Submission by Mallard Pass Action Group (MPAG)

# Deadline 9

**APPENDIX 1**: Comments from Landscope on the Applicant's response to their soil report (REP7-060) on behalf of MPAG.

Plan KCC3051/01A
Auger Point Plan

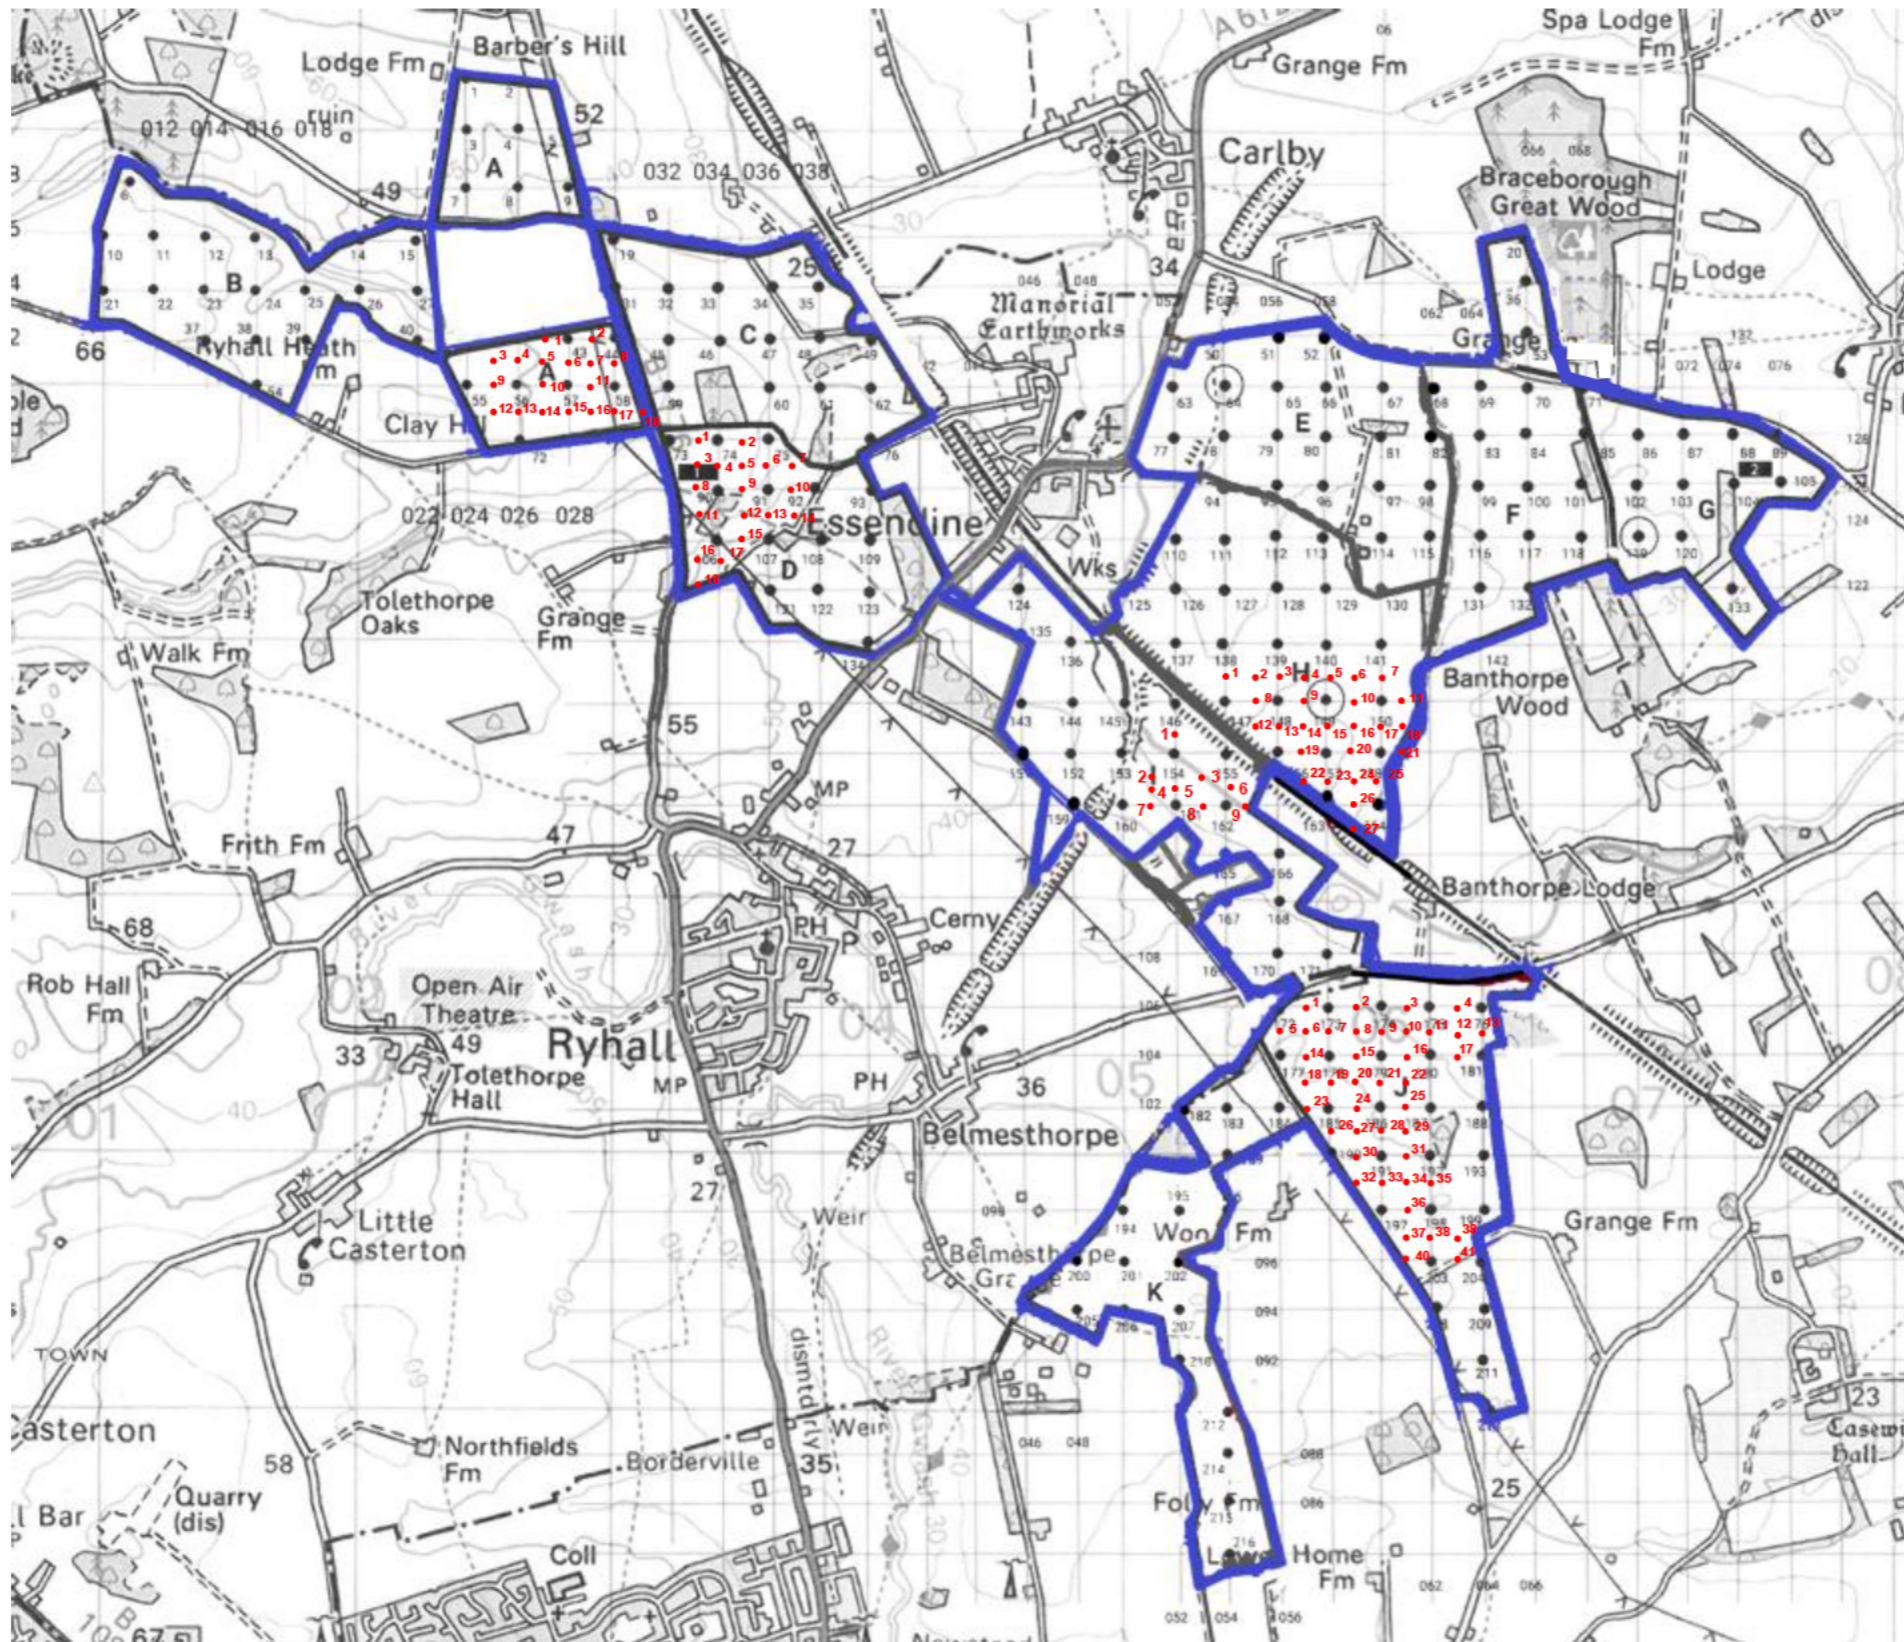
The ES did not contain the semi-detailed map layout of ALC grades from the PEIR, therefore there was no comparison between detailed and semi-detailed results. Therefore it would have been impossible to identify all the areas that changed (downgraded) that were not sampled at a detailed level. The plan map of auger bore points in Appendix 12.4 (APP-091) are quite small and of poor quality, making identification difficult. Landscope used the grid references in the KCC test results to overlay their map requiring 30 auger samples.

Landscope is not critical of the findings made by KCC, but even in the areas surveyed such as Field 2 the density of survey was not in compliance with TIN049, in that there were 24 and not 30 boreholes. Where Landscope did survey we found sufficient discrepancies or difference with the KCC report to suggest that there is or could be more BMV than the surveys of KCC.

8.2 The Landscope survey focuses mainly on one field. As Landscope record in paragraph 1.5 [REP7-060] KCC have sampled 24 auger points over the 30ha field. In 1.6 it is stated that "we consider that a full ALC survey across the whole site is justified to determine more precisely the quantity of BMV land". This implies that 24 points over 30ha is not considered to be enough.

That is correct, especially as grade 2 land was also involved. Given that KCC would want to demonstrate accurately their findings that the land should be downgraded from the preliminary findings, then it would seem appropriate for the full 30 auger samples to have been taken. Landscope found differences and when looking in the Grade 2 area and found even more Grade 2.

Figure 12.1
ALC Across Order Limits

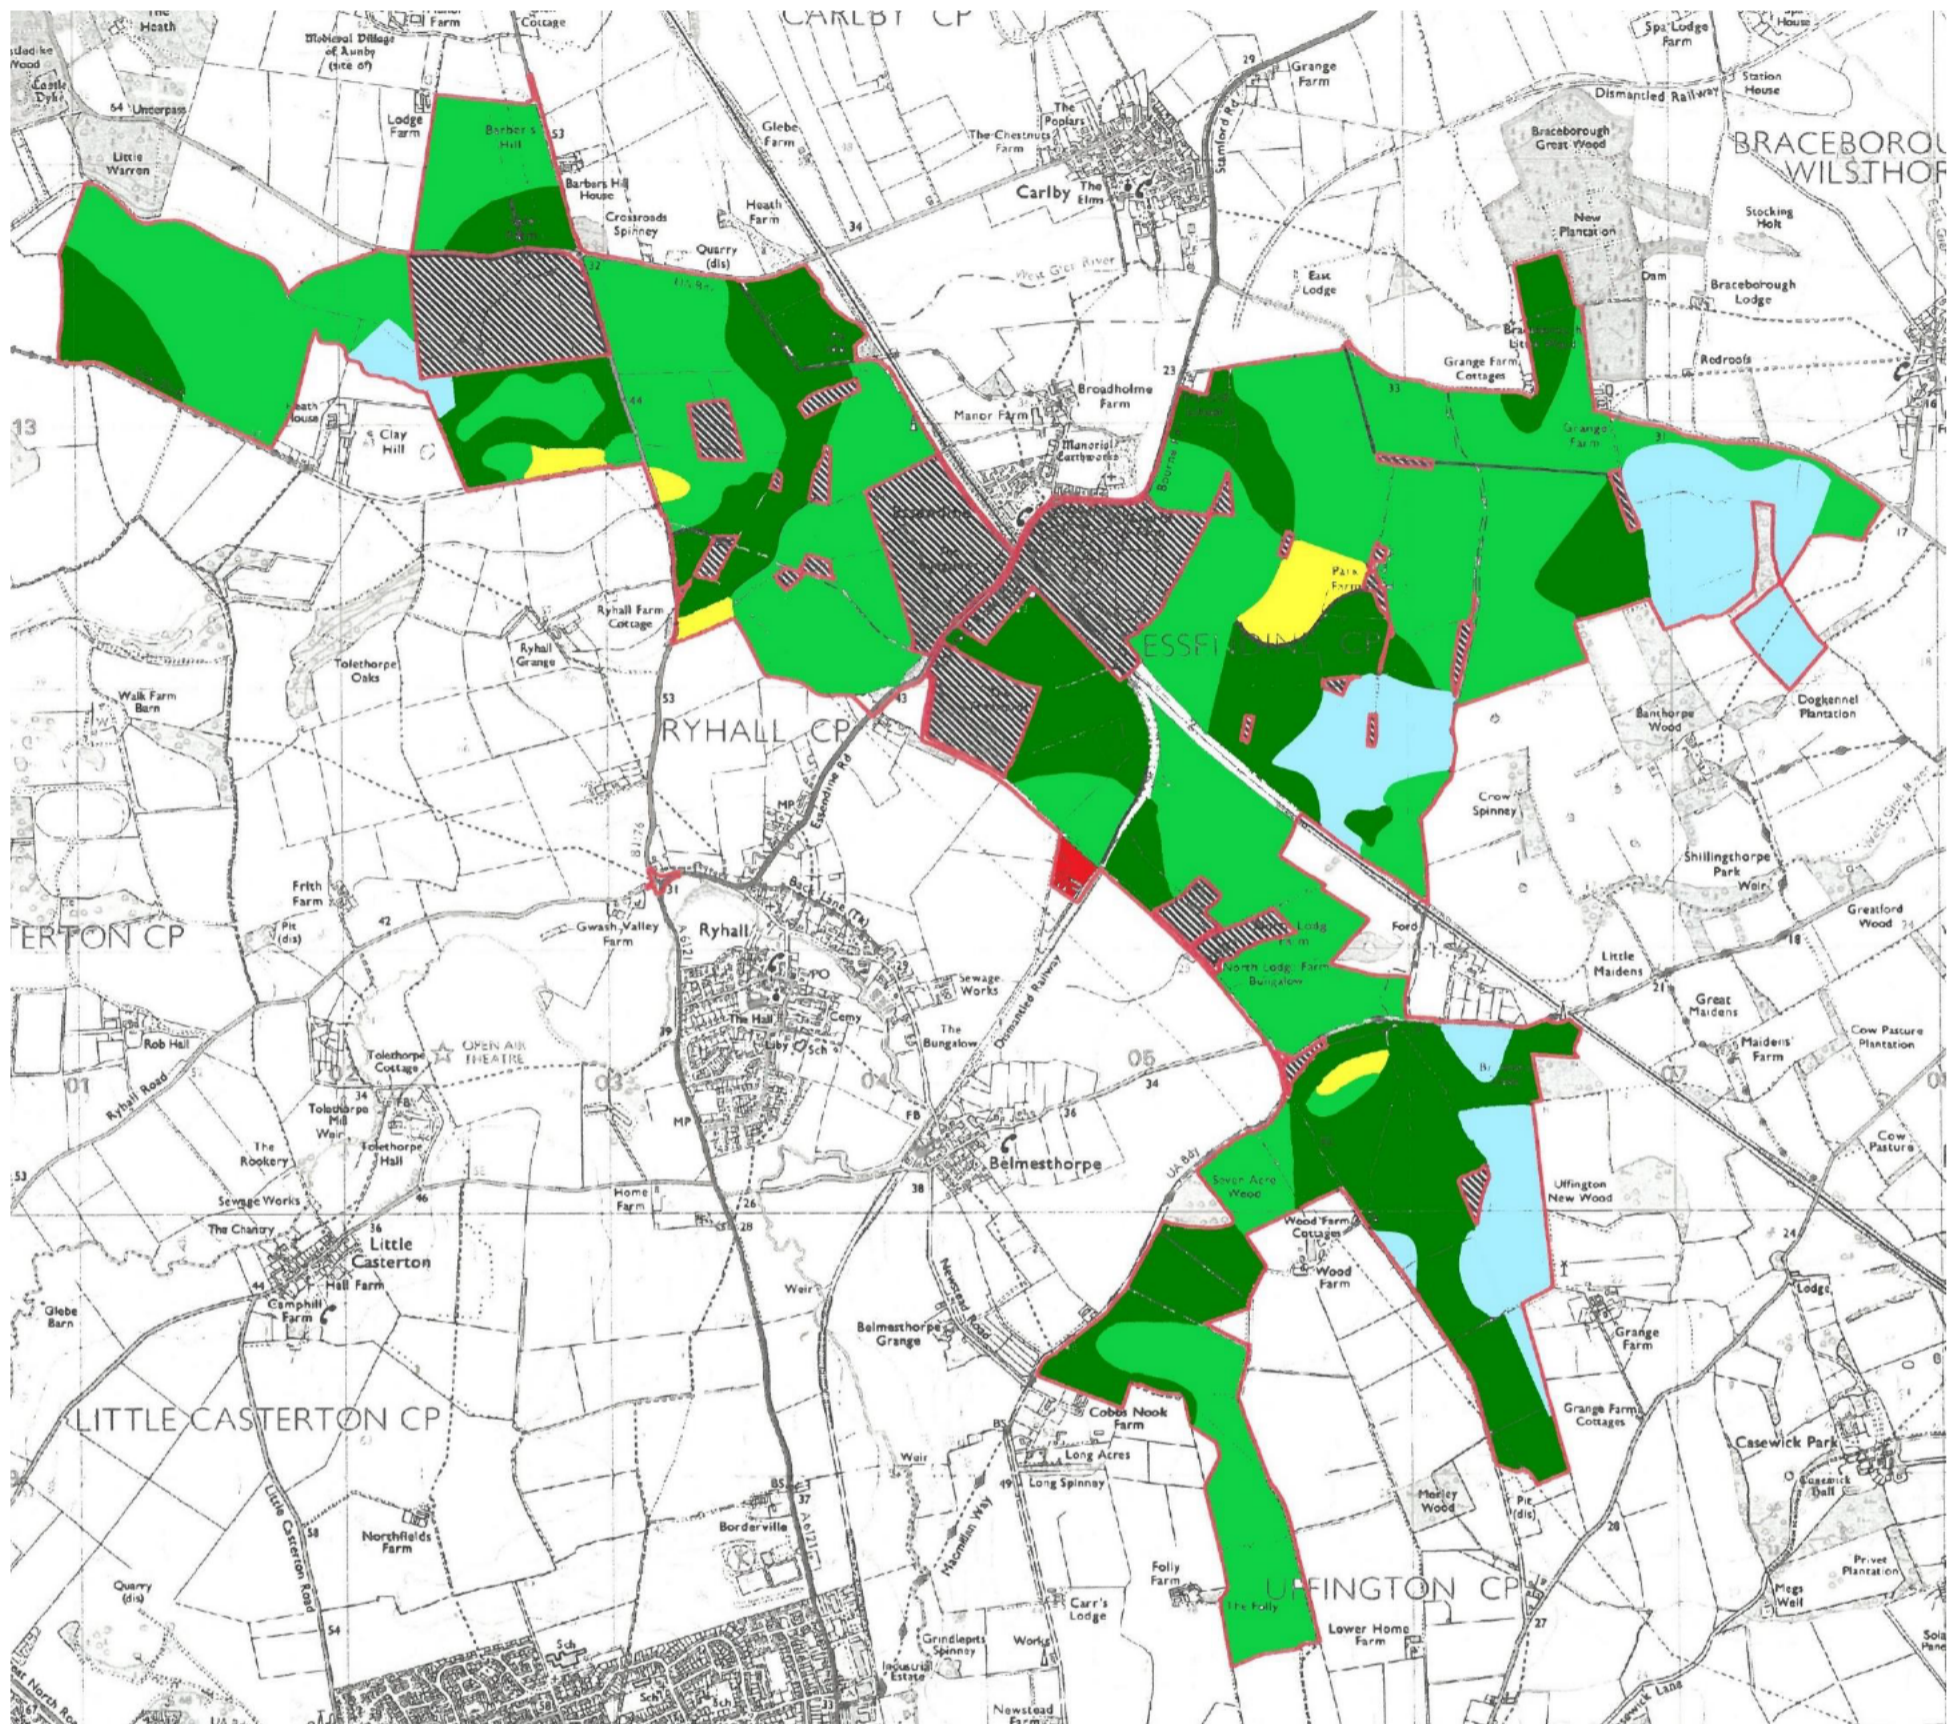
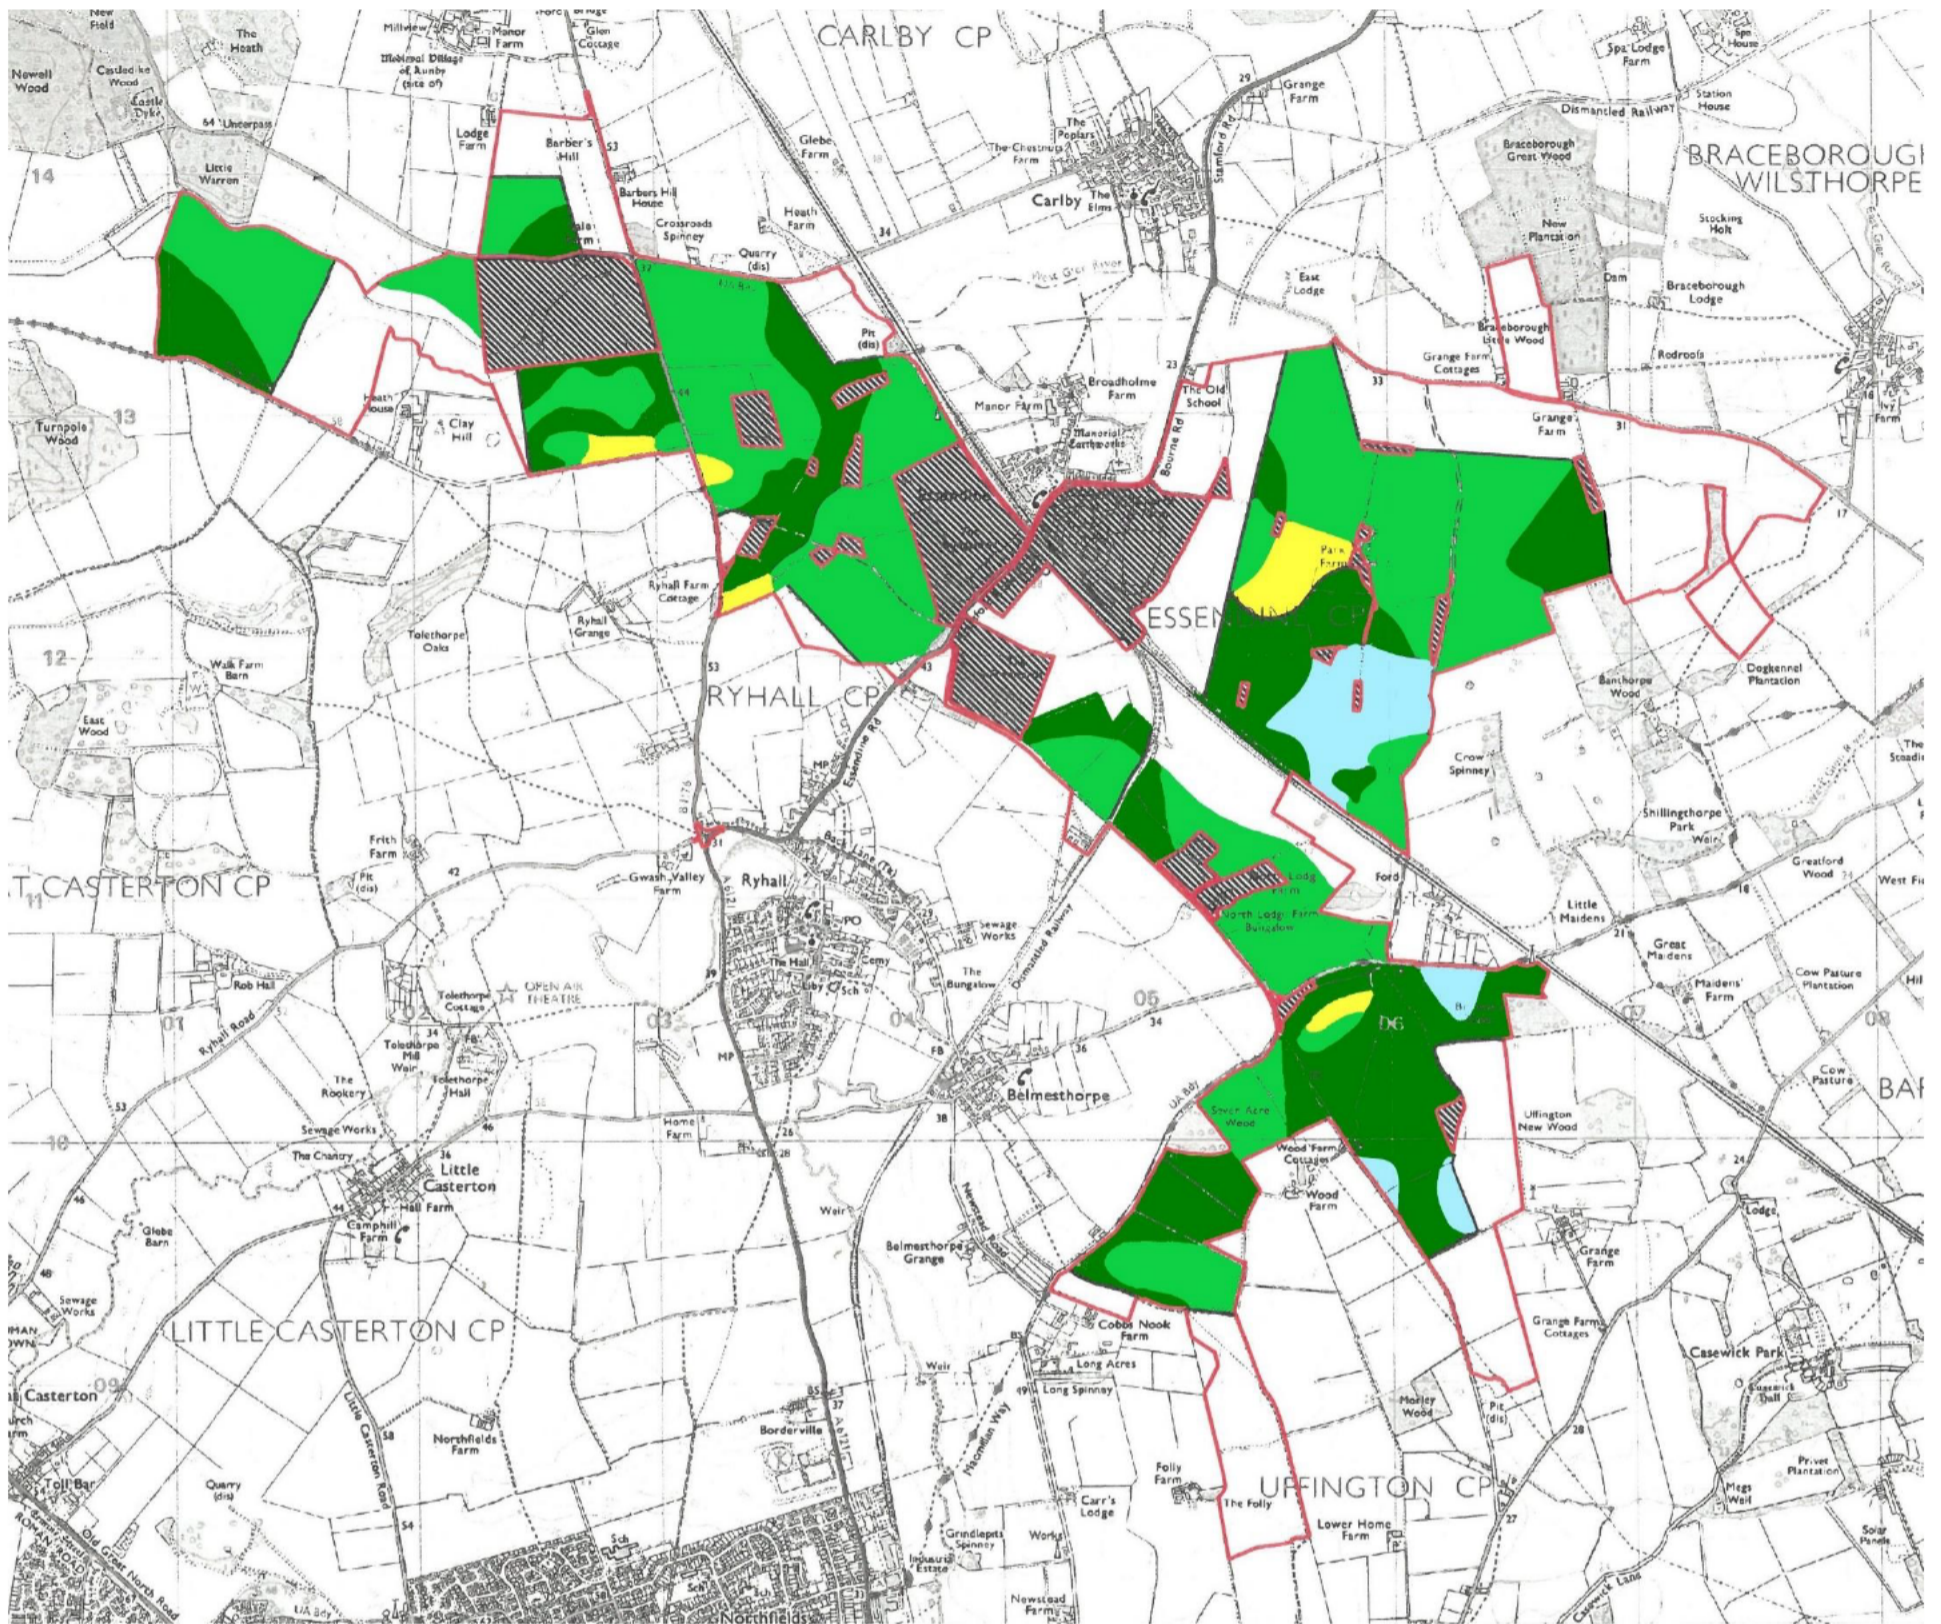
There is no final design yet for solar panel layout, tracks, solar stations, cable routing etc, so how did the Applicant arrive at their ALC grades for these areas? They have not correctly reflected the BMV of field 19 which houses the substation and will be an area which is permanent.

8.5 Landscope then extrapolate their findings. The conclusion in 7.1 is that not all the BMV has been identified on the site (the implication is that they are referring to the whole Site not just field 2). Yes It is stated that areas of Subgrade 3b that were not resurveyed (i.e. detailed survey) may contain some 3a or higher.

This was a distinct possibility. Since the KCC findings place the Likelihood of BMV into the 'Moderate Likelihood' rather than the expected 'Low Likelihood', it demonstrates that there is a reasonable chance of more BMV across the site. KCC don't know, because they did not re-survey the areas they previously identified as 3b.
